**37 Tate Street - Permit 2018-00064**

I have completed my initial zoning review and I need more information before I can approve the permit application and move it forward in the review process.

a1

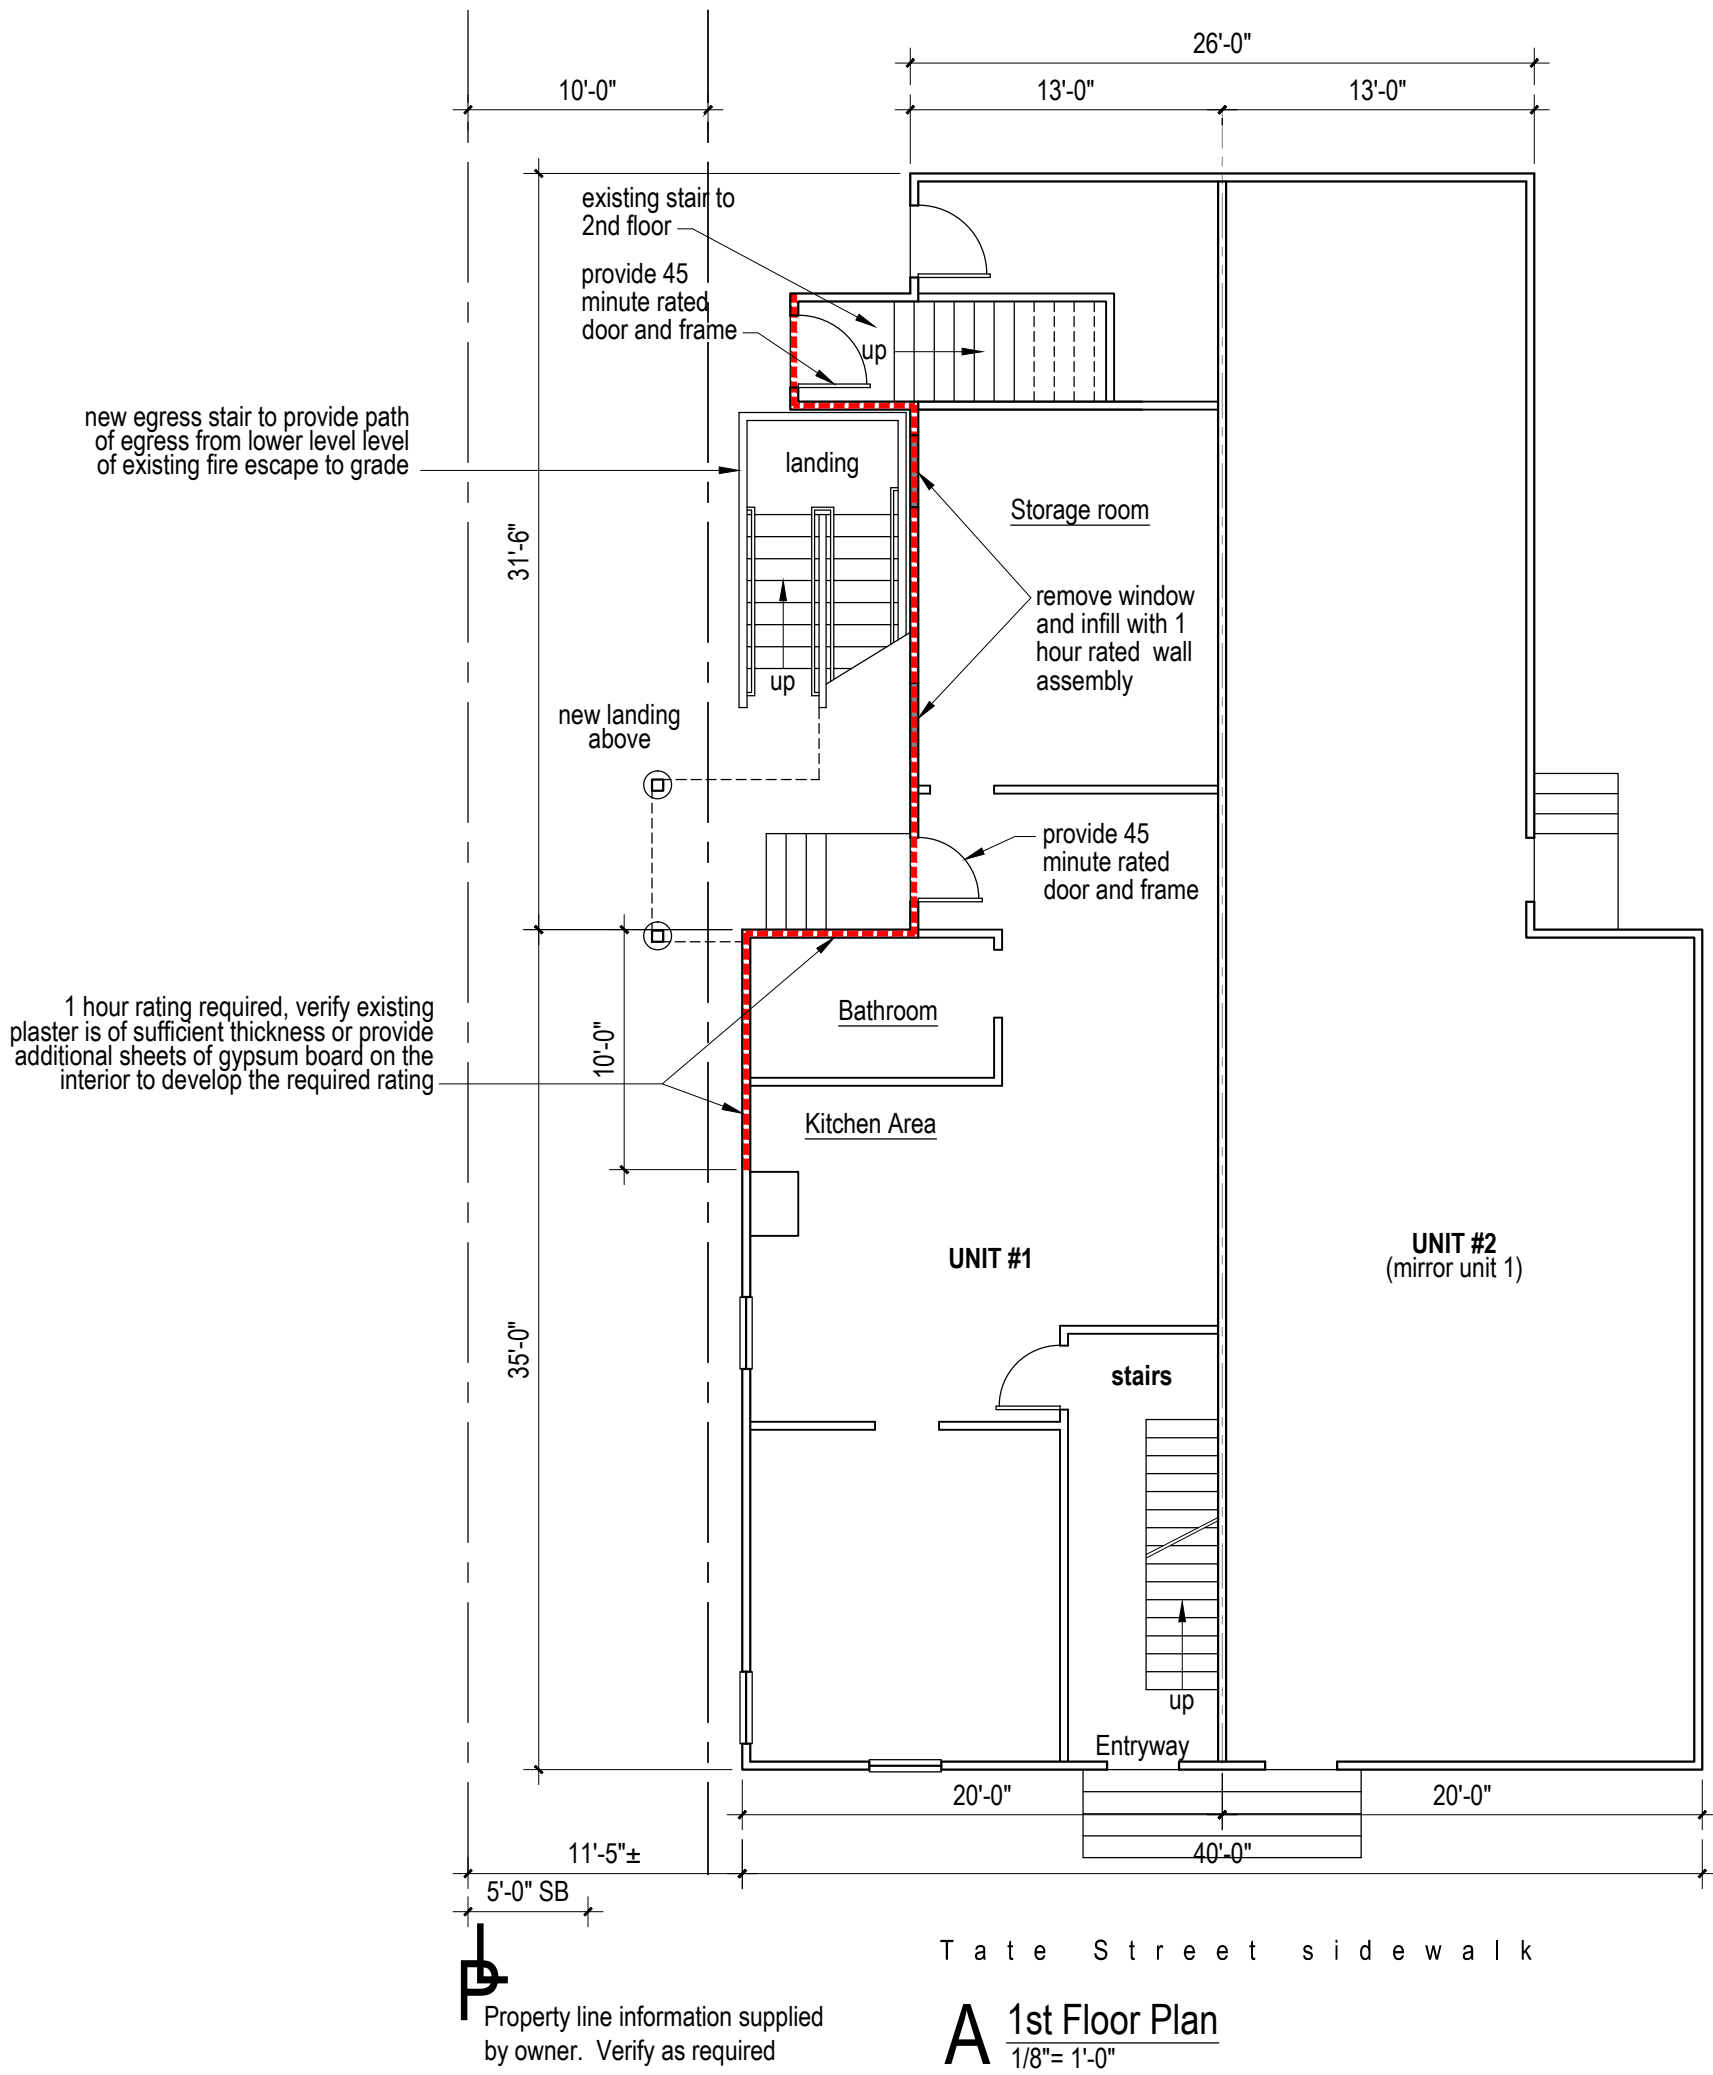
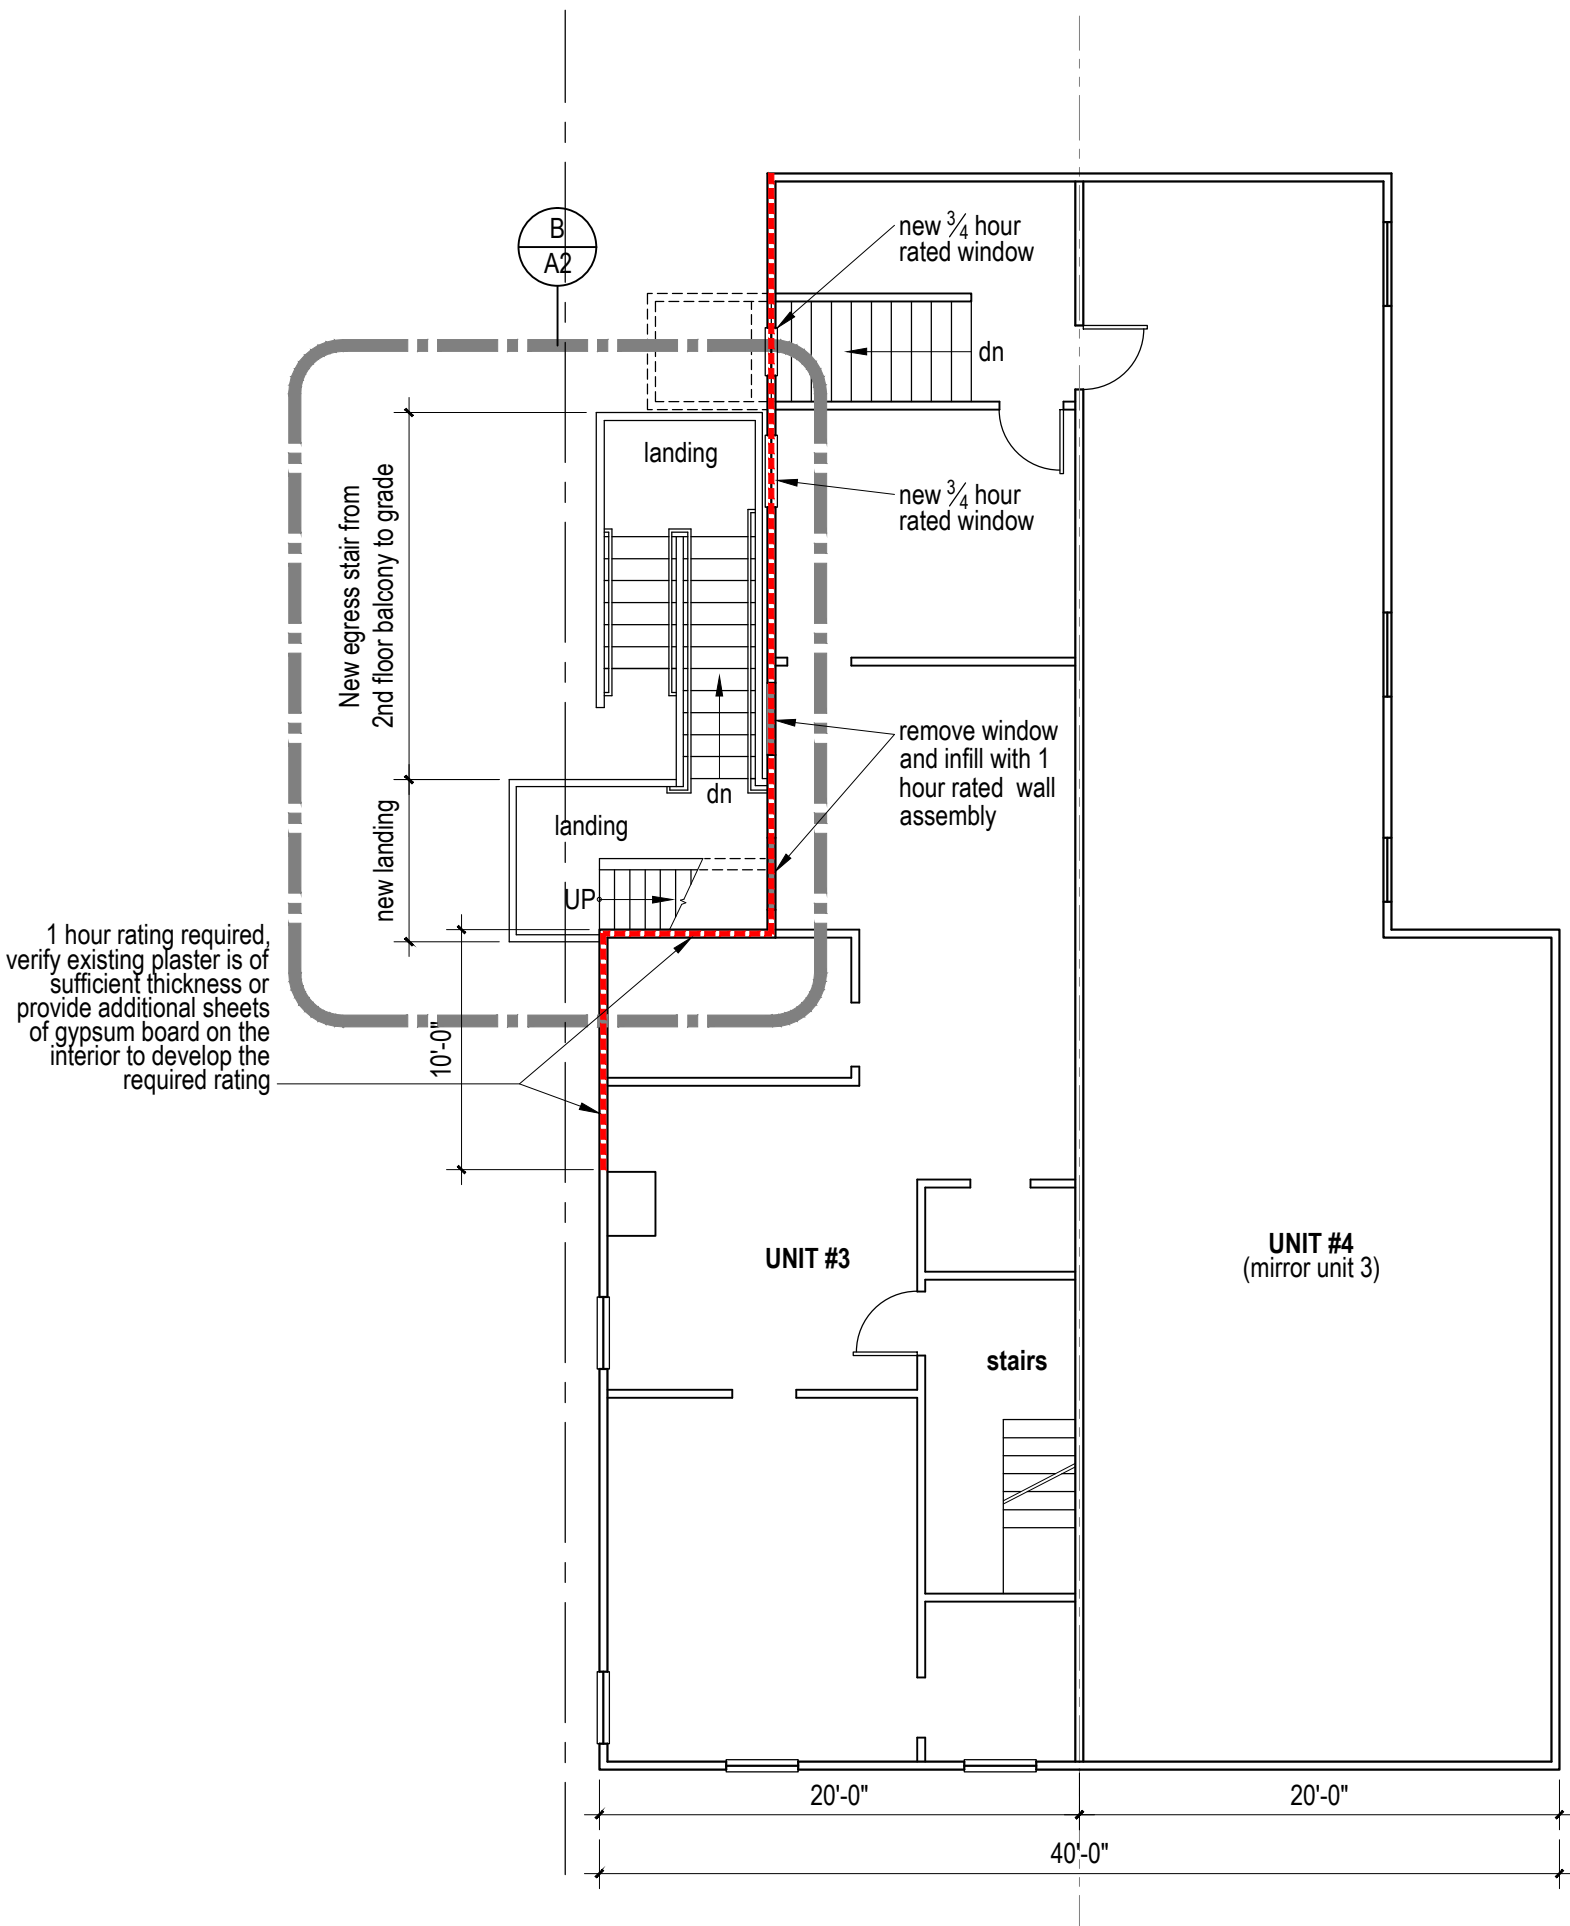
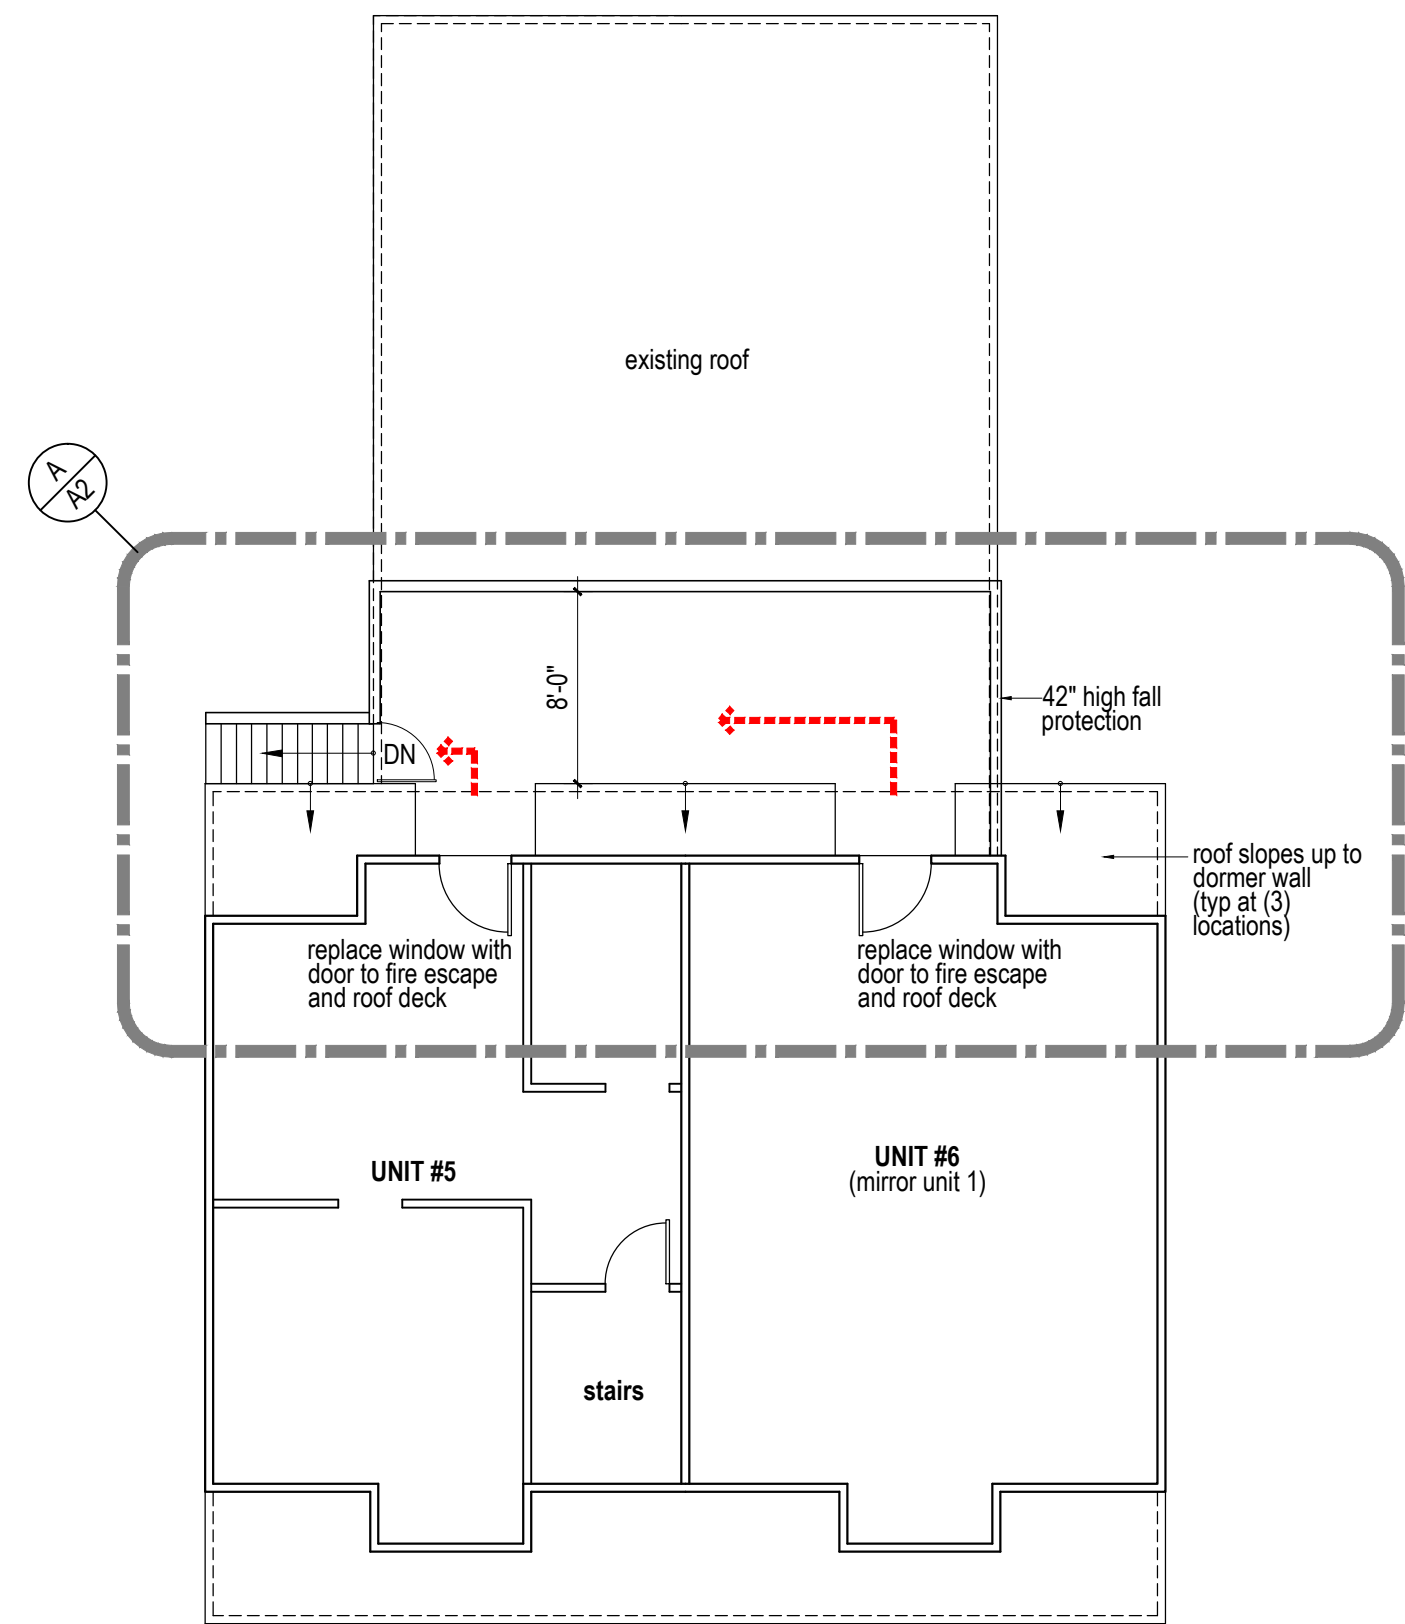
1. The plot plan needs to be more detailed. Exhibit A of the deed describes the dimensions of the lot as 31' wide by 70' deep. You need to show the footprint of the existing fire escape on the plot plan as well as the footprint of the proposed stairs from the second floor fire escape to the ground. Each of these footprints should include their dimensions and I need to know how many feet they are from both the side property line and the rear property line.

4. The plan labeled "egress 2" shows that the second floor apartment has two means of egress - a set of stairs in the front and a set of stairs in the rear. There is no need for a fire escape for egress from the second floor unit.

5. The plan labeled "egress 3" shows the third floor apartment. There is no interior stair shown to access this unit. You need to revise this plan to show the primary means of egress. It appears that the proposed fire escape is only required as a second means of egress for the third floor unit.

6. You need to provide an exterior elevation plan or plans that show the existing fire escape. You also could provide pictures as well. Did the fire escape originally extend to the ground floor? You also did not provide any plans showing how the new stairs are going to be built. You need to show a cross section of the fire escape, framing details and any other plans that show the construction of the fire escape.

It is not clear exactly what the dimensions are for the existing fire escape. The different plans seem to give different dimensions. Please provide one plan that gives the dimensions for what is existing. You still need to provide more details about how you are rebuilding the fire escape to the ground. What are the dimensions of it? How wide is it? How long is it? How many stairs? I also did not see a plan that shows a cross section of the fire escape and elevations from the side and the rear. Please provide these drawings.
